**Application by EPL 001 Ltd for Stonesreet Green Solar**

**The Examining Authority's written questions and requests for information (ExQ1)**

**Issued on 10 January 2025**

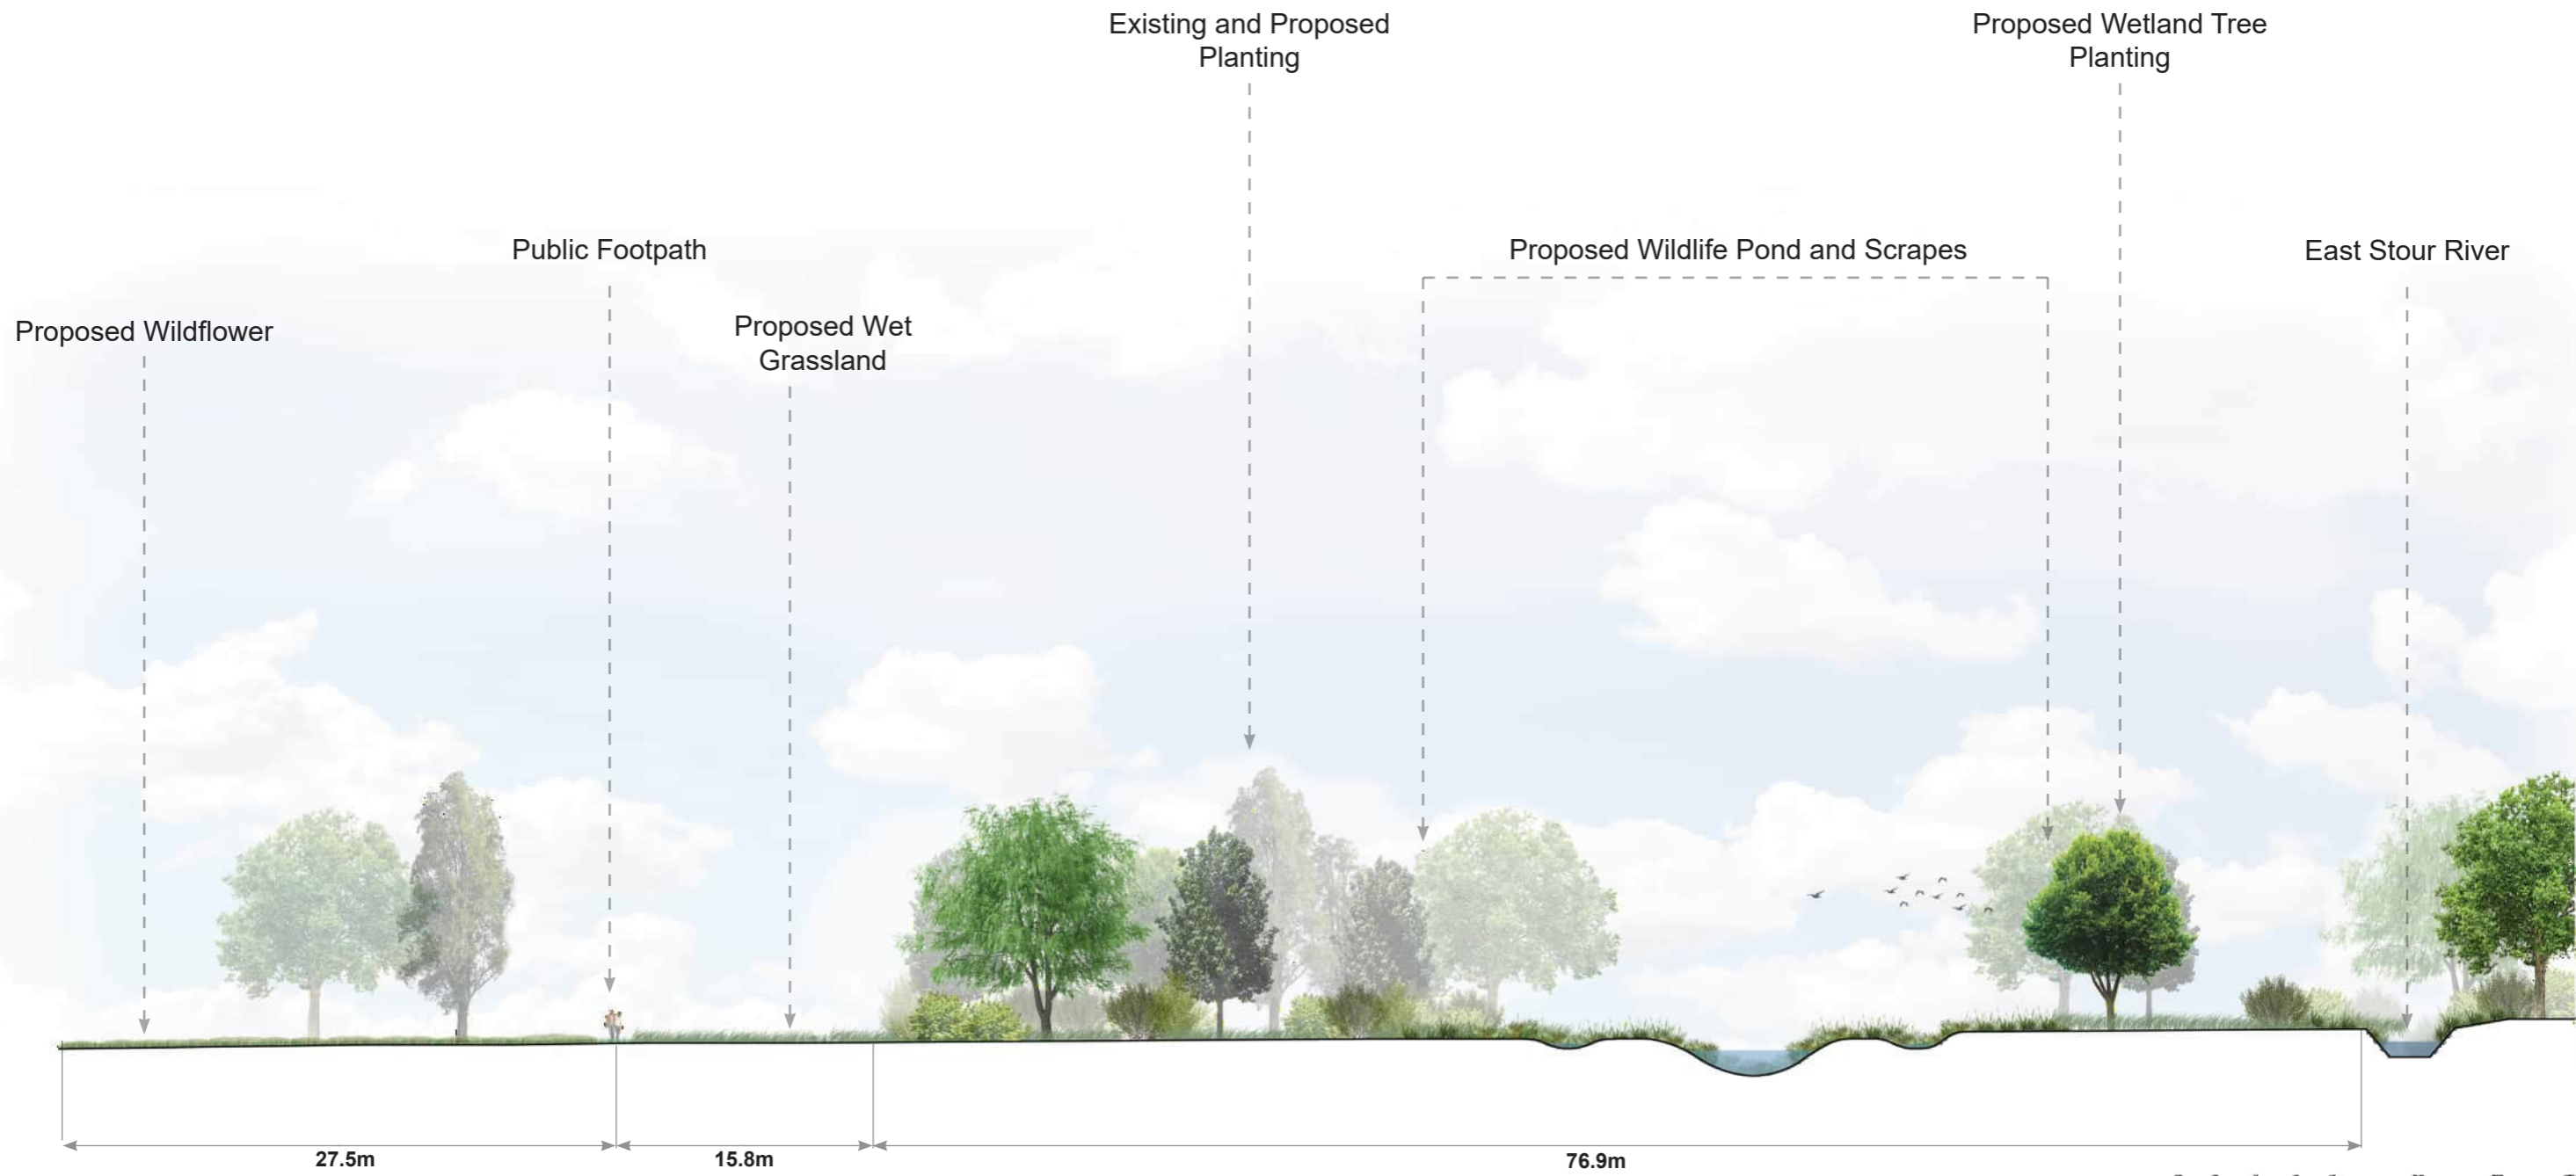
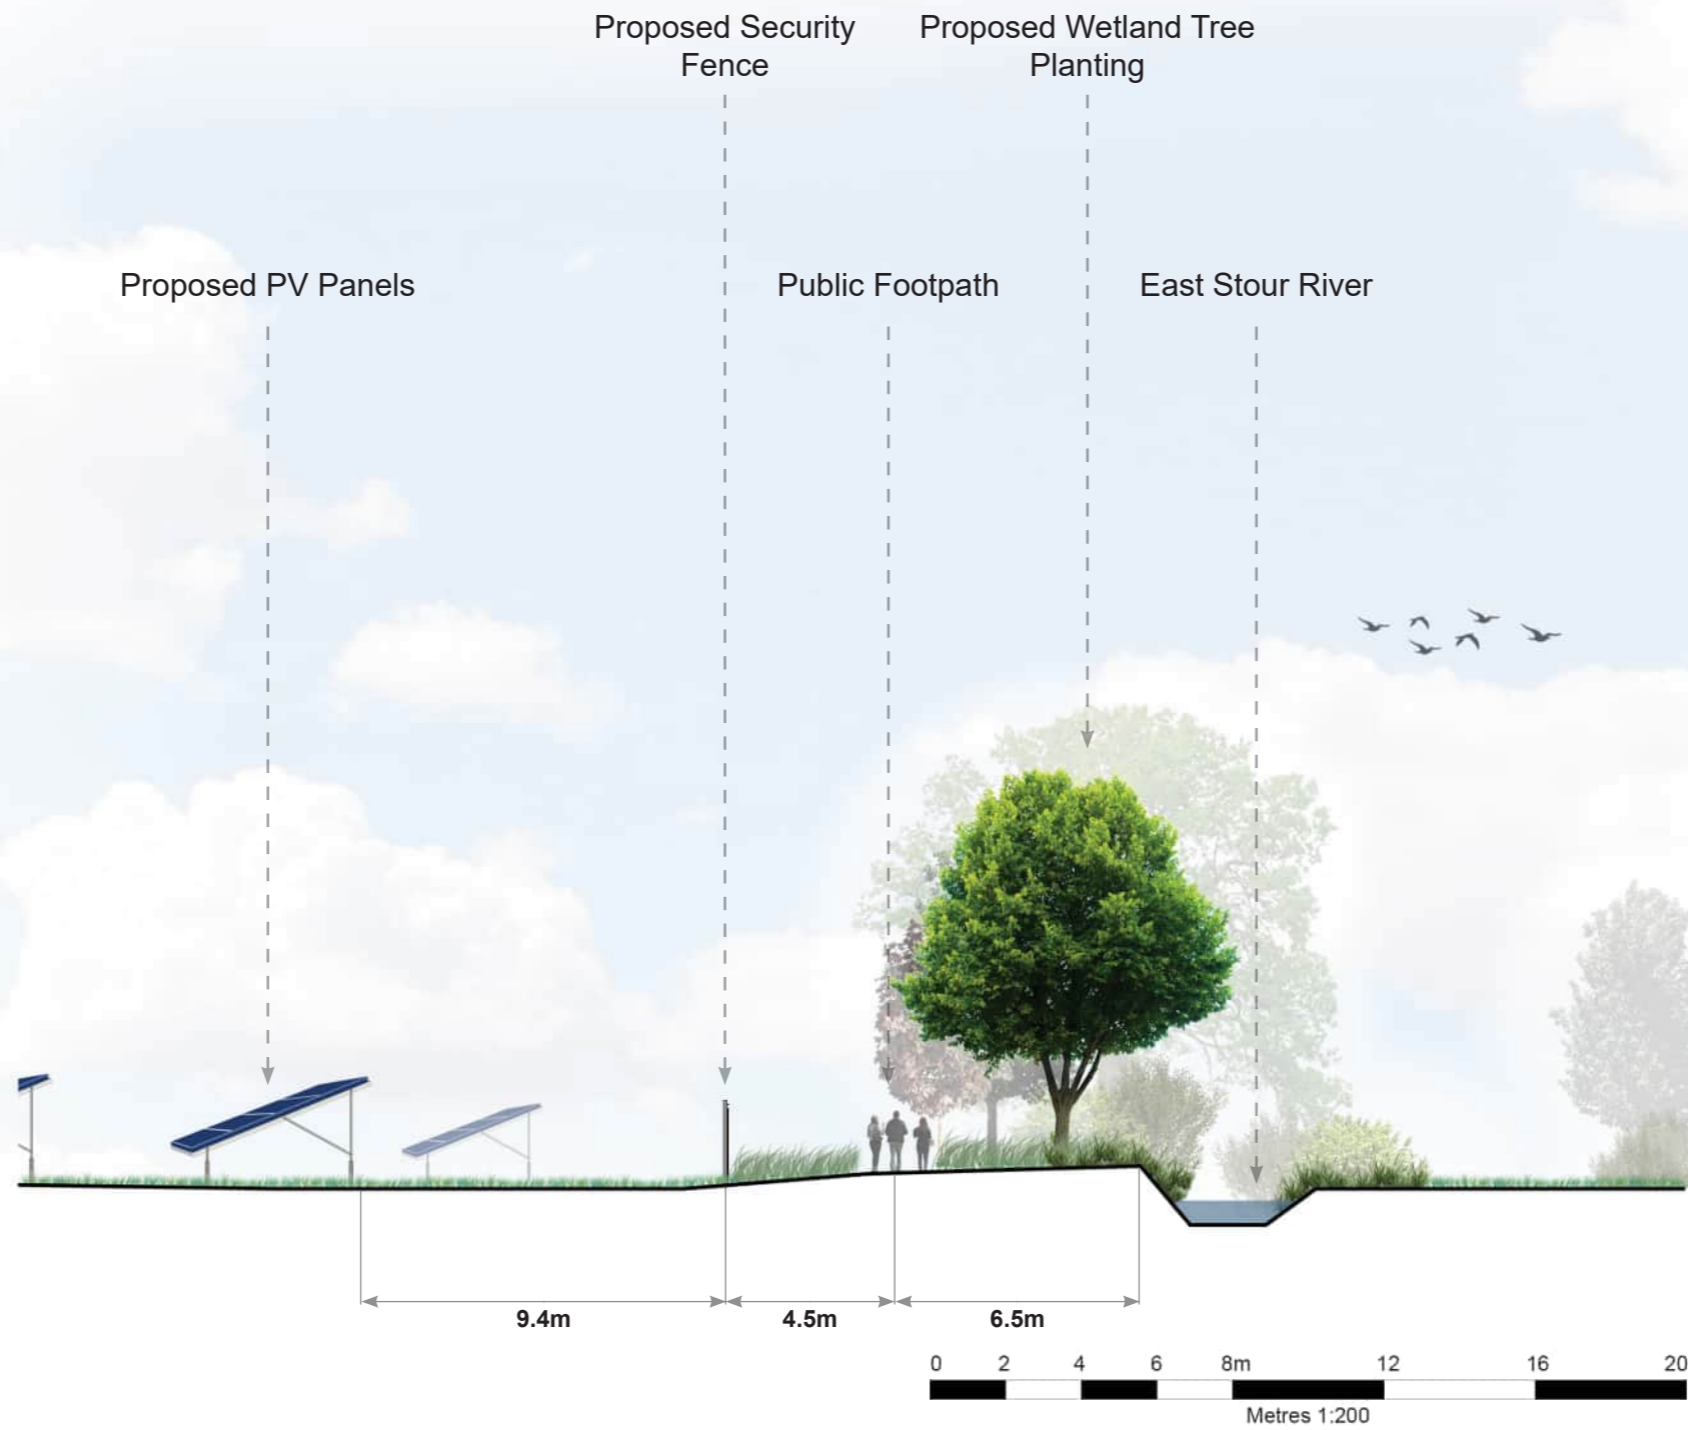
ExQ2	Question to:	Question:
Q7.0.7	The Applicant	<p><b>LVIA Convention</b></p> <p>Chapter 8 Landscape and Views [AS-014] – page 29 in response to KCC’s comments on the 15 year maturity of landscaping, you state “The 15 year timescale for the assessment is an LVIA convention, rather than being related to the maturation of planting. “Please reference where the ‘convention’ originates from and consider outlining why earlier planting or use of mature standards should not be used in this instance to improve mitigatory measures.</p>
Q7.0.8	The Applicant	<p><b>Landscape Planting</b></p> <p>Table 8.4: 2023 Statutory Consultation Response Summary of the ES Chapter 8 Landscape and Views [AS-014] states: ‘Where possible, advanced landscape planting will be carried out in advance of the construction phase to maximise the screening potential of proposed planting in the early phases of the Project. The proposed planting has also been amended to include a greater proportion of larger stock, which would also help address this point’. However, the Outline LEMP [APP-155] states in Paragraph 4.3.3 ‘Advanced planting is likely to commence in the first available planting season (November to March inclusive) following the granting of development consent. The remainder of proposed planting would be undertaken in the first available planting season following the construction of the Project’. Clarification is sought as to the extent of advance planting and how it has been prioritised and for the Applicant to review this matter and the amount of detail shown on the illustrative landscape drawings (<b>Doc 2.7</b>). What is the operational year represented by the size of the trees and shrubs shown in Section 1 (Doc 2.7 Drawing No. 011998.00001.716) to Section 6 (Doc 2.7, Drawing No. 011998.00001.721)?</p>
